CITY OF PORTLAND

Permit Number: 061066

AT 71 BALLPARK DR _____ 371 A040001

Proposed Project Description: Single family w/ attached garage	FIRE DEPT: <input type="checkbox"/> Approved <input type="checkbox"/> Denied <i>N/A</i>	INSPECTION: Use Group: <i>R-3</i> Type: <i>SB</i> <i>IBC 2003</i>
	Signature:	Signature:

FIRST FLOOR PLAN
Scale: 1/4" = 1'-0"
2129

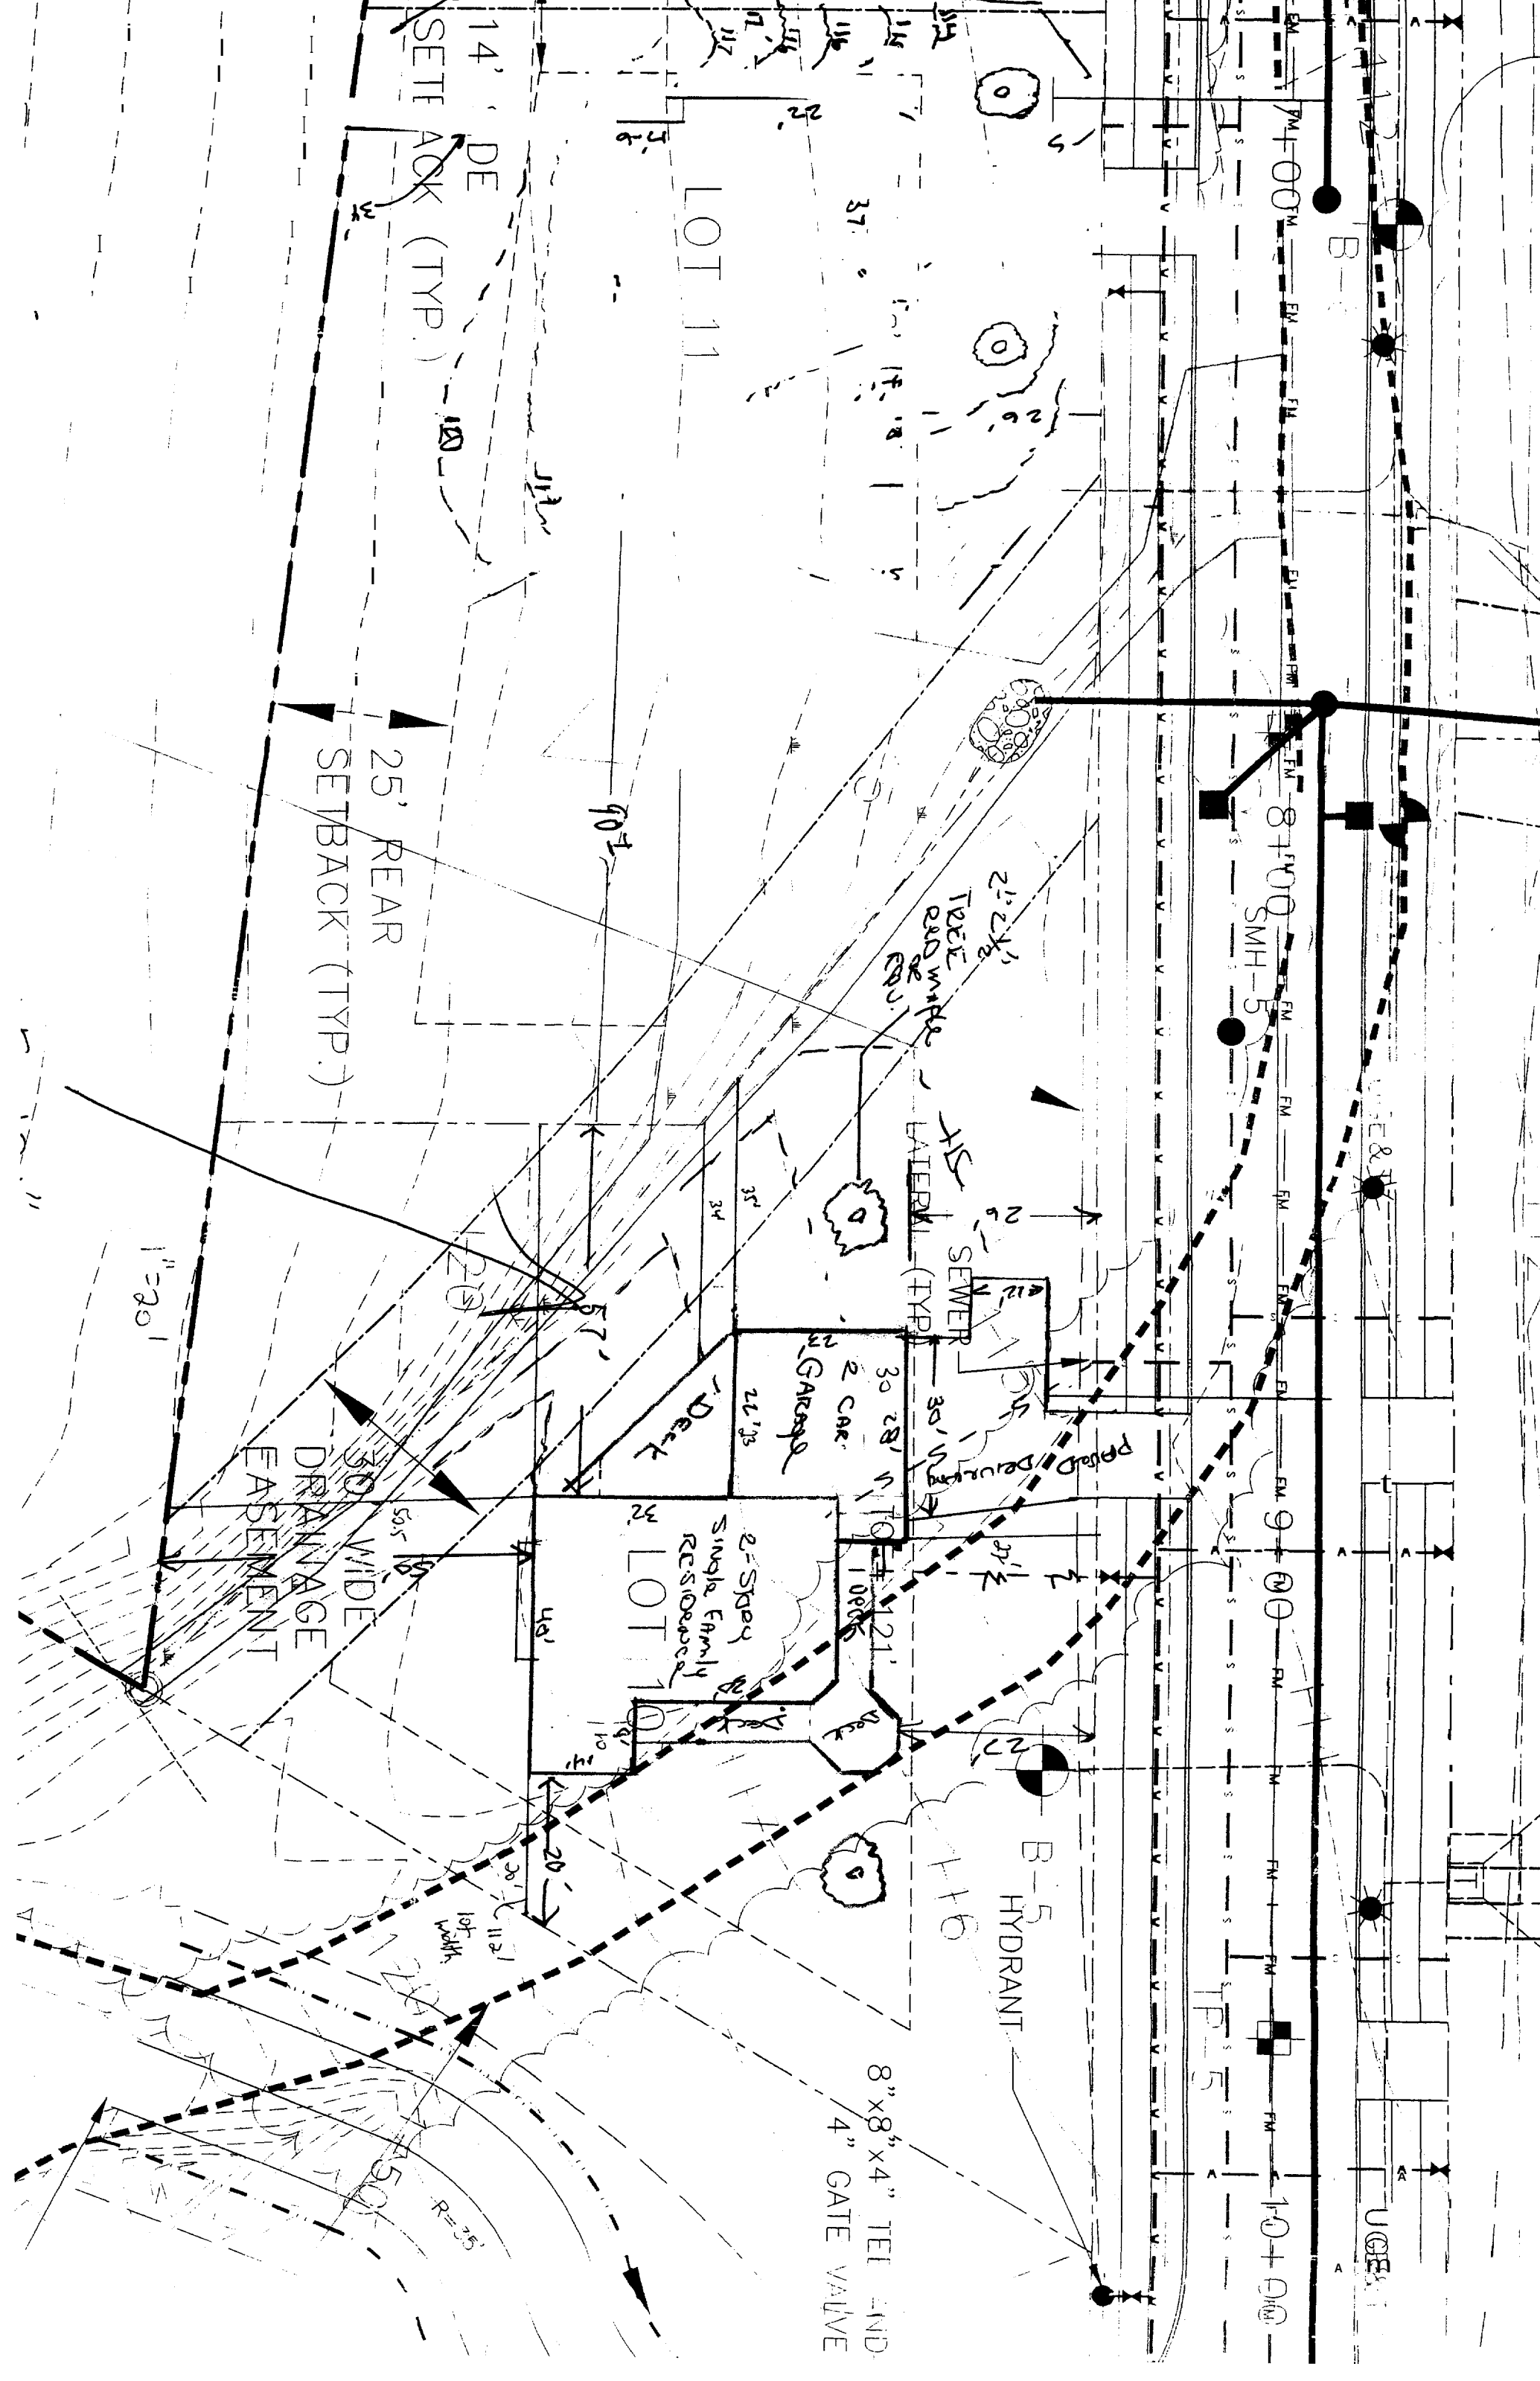
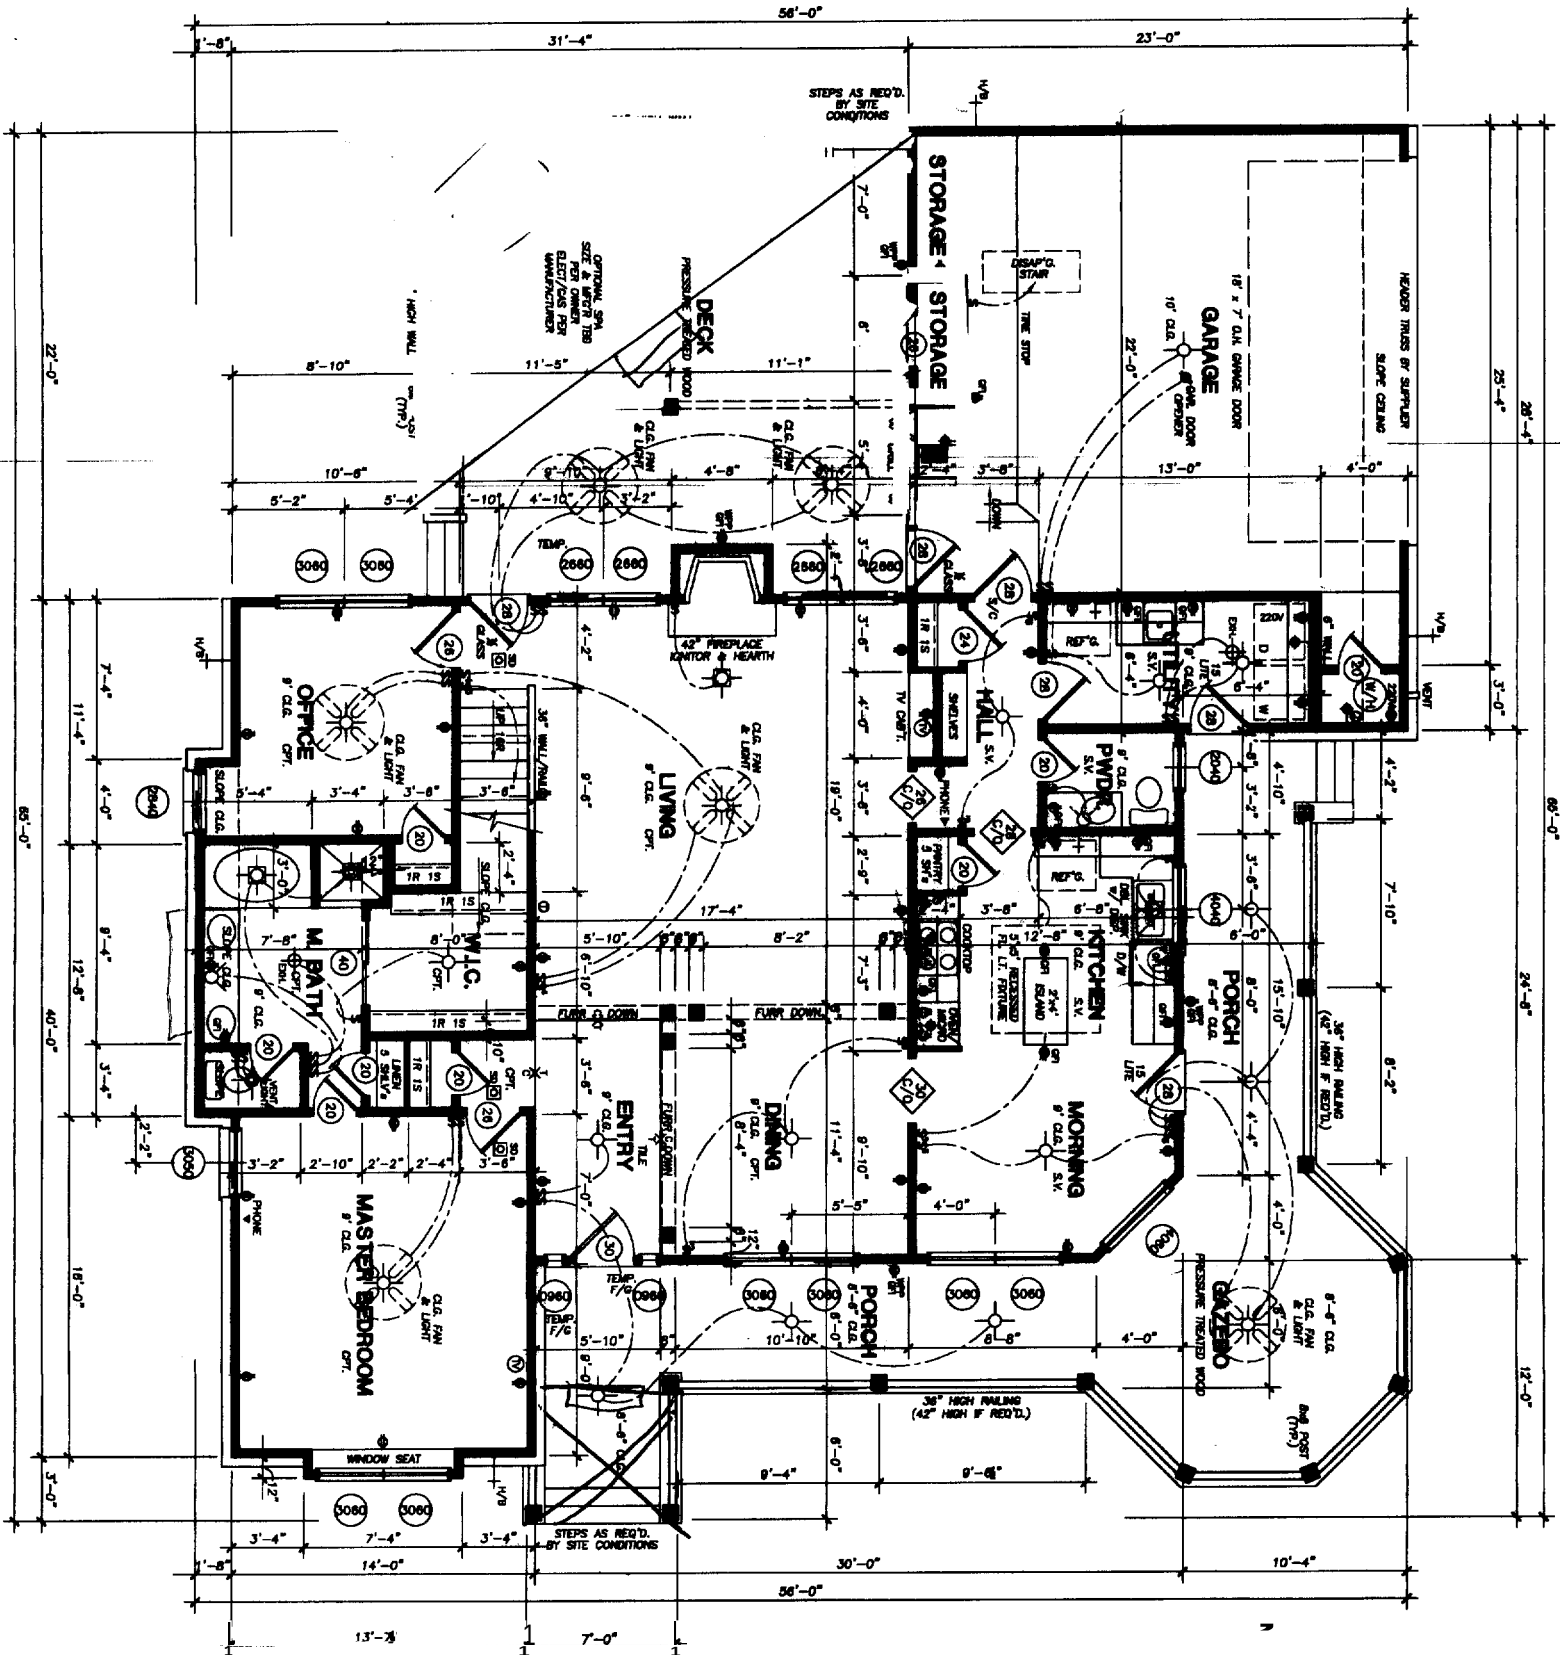
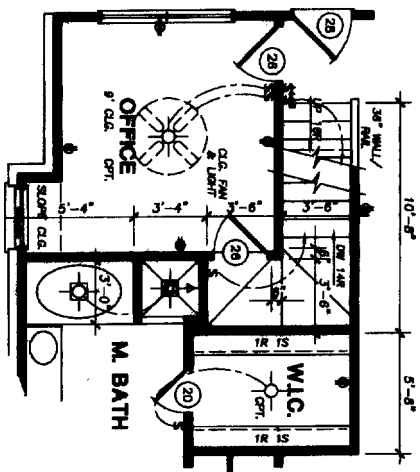
- 9) There must be a 2" clearance maintained between the chimney and any combustible material, with draft stopping per code at each level
- 10) The large triangular deck is not approved at this time. An ammendment must be filed with construction documents in order to approve this.

SECOND FLOOR PLAN
Scale: 1/4" = 1'-0"

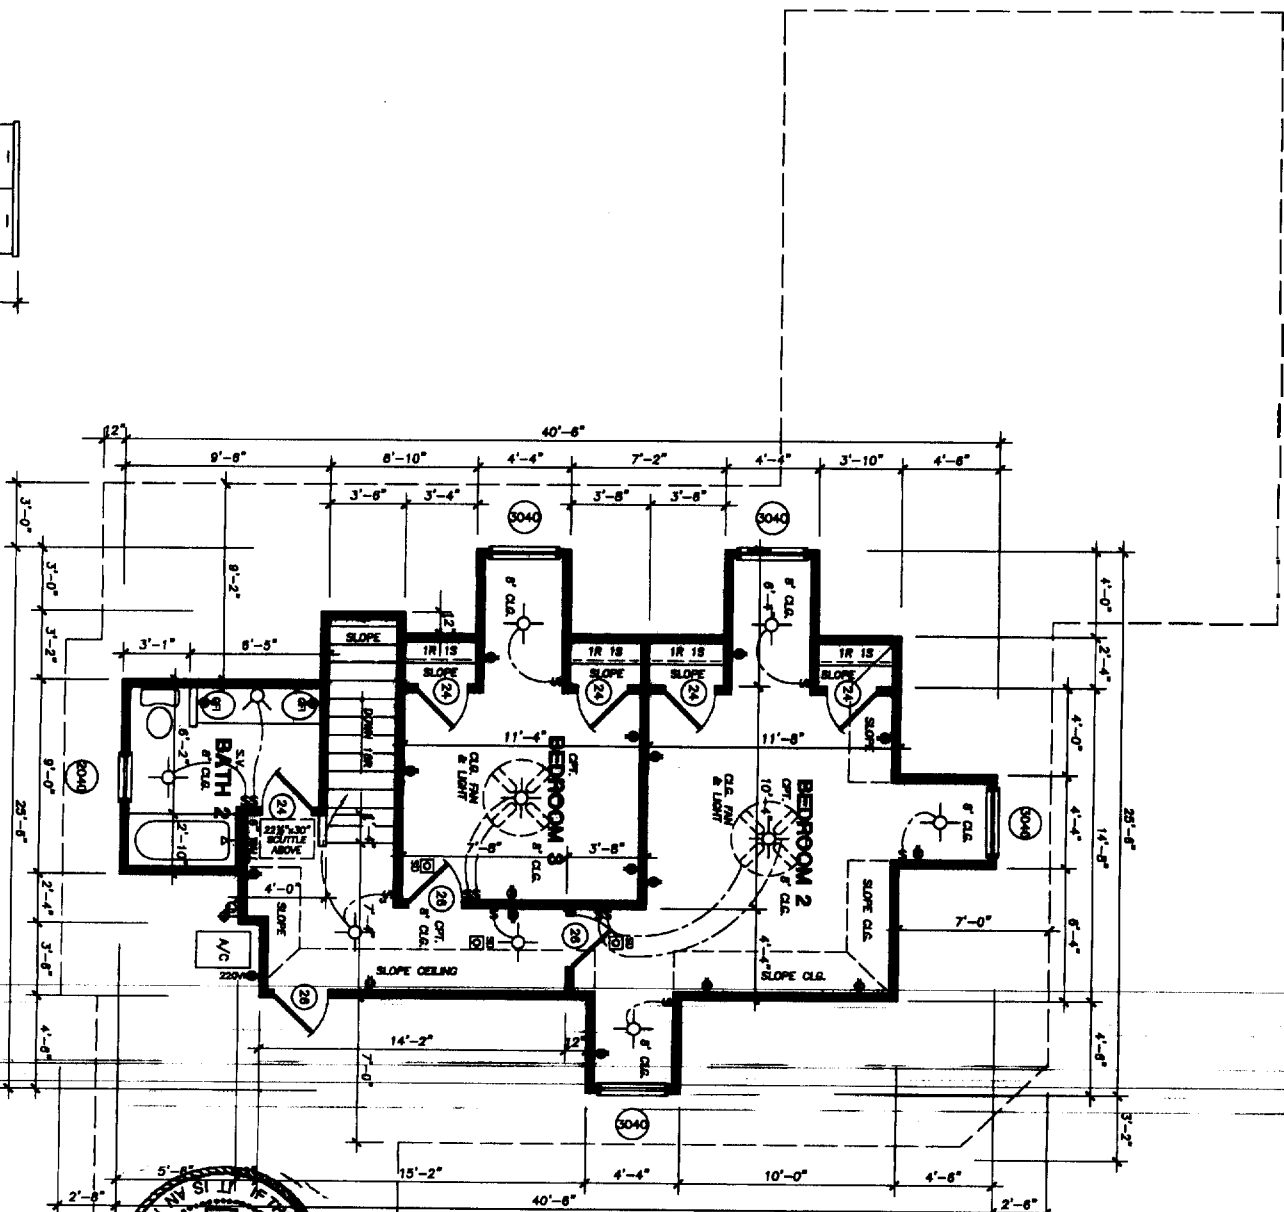
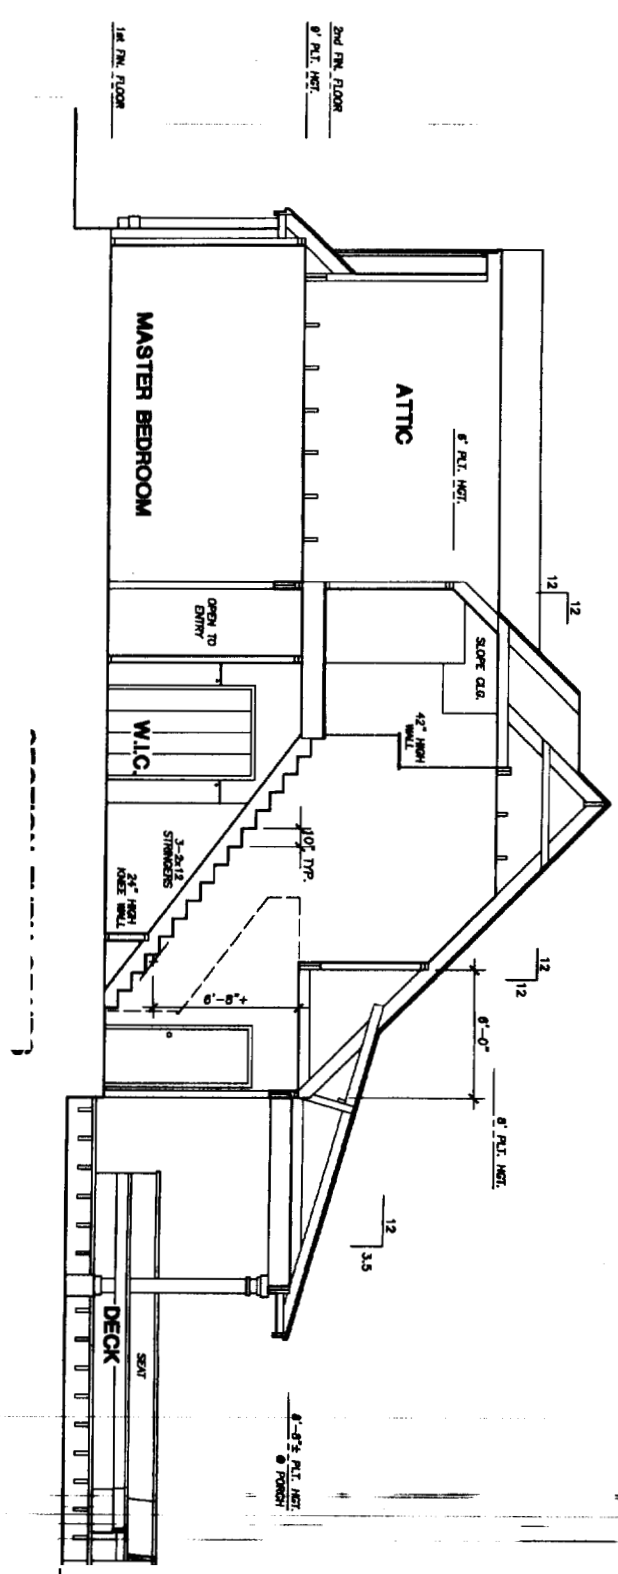
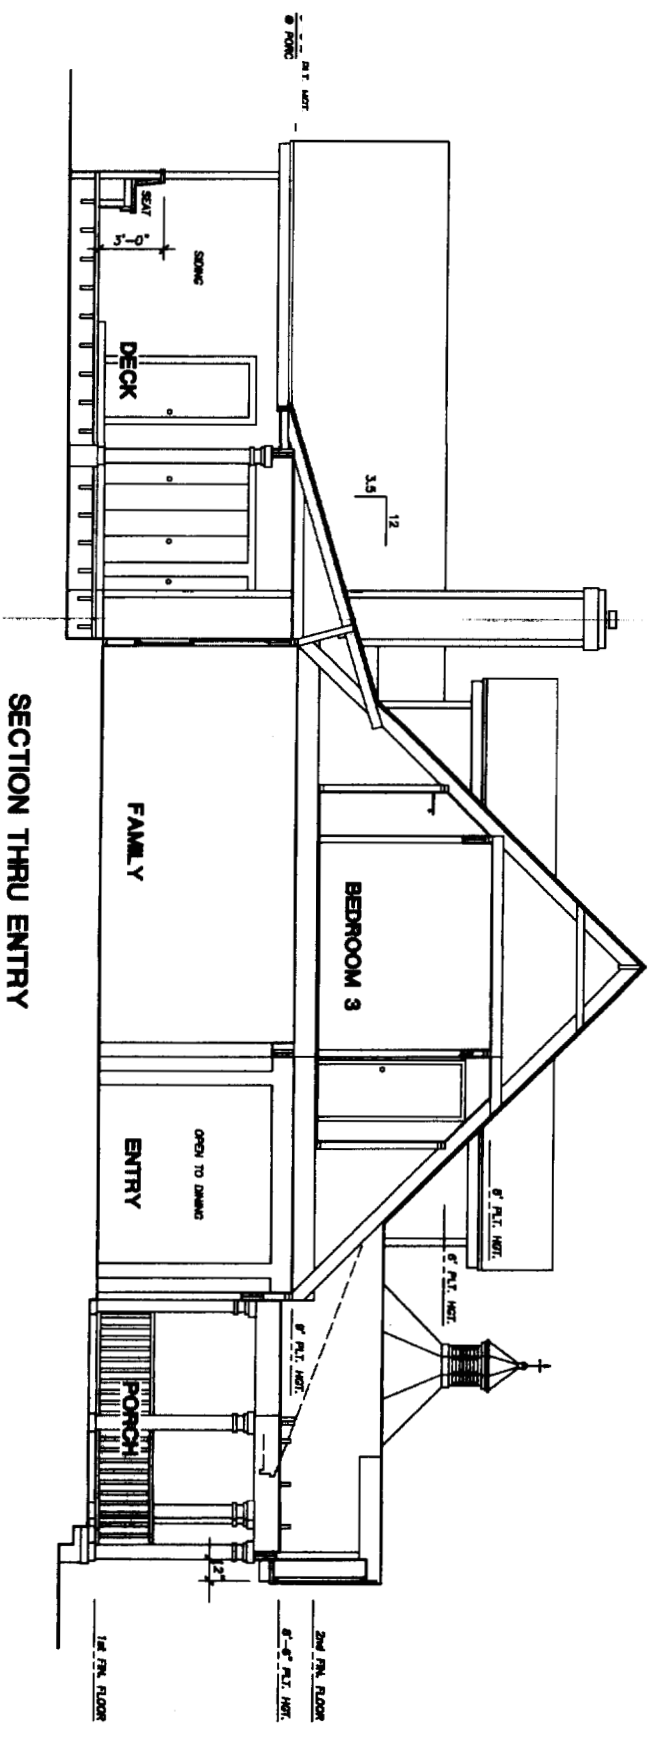
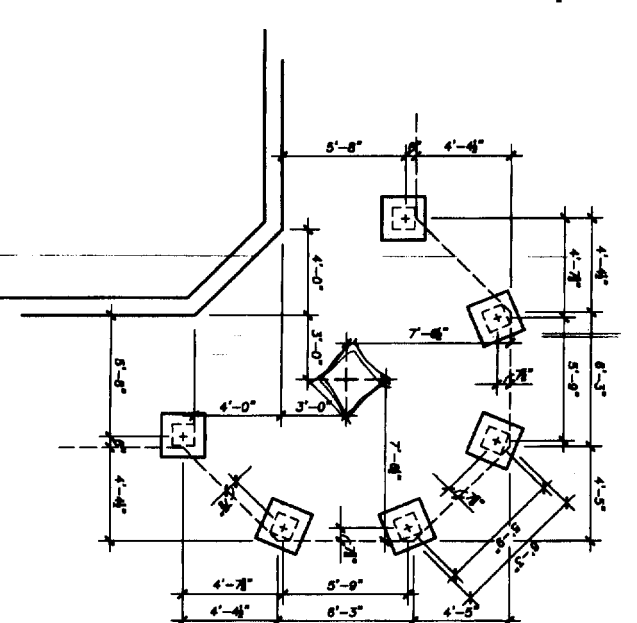
Handram not shown in second floor. 8'-0" curbs - 12514

Headroom not shown in second floor.
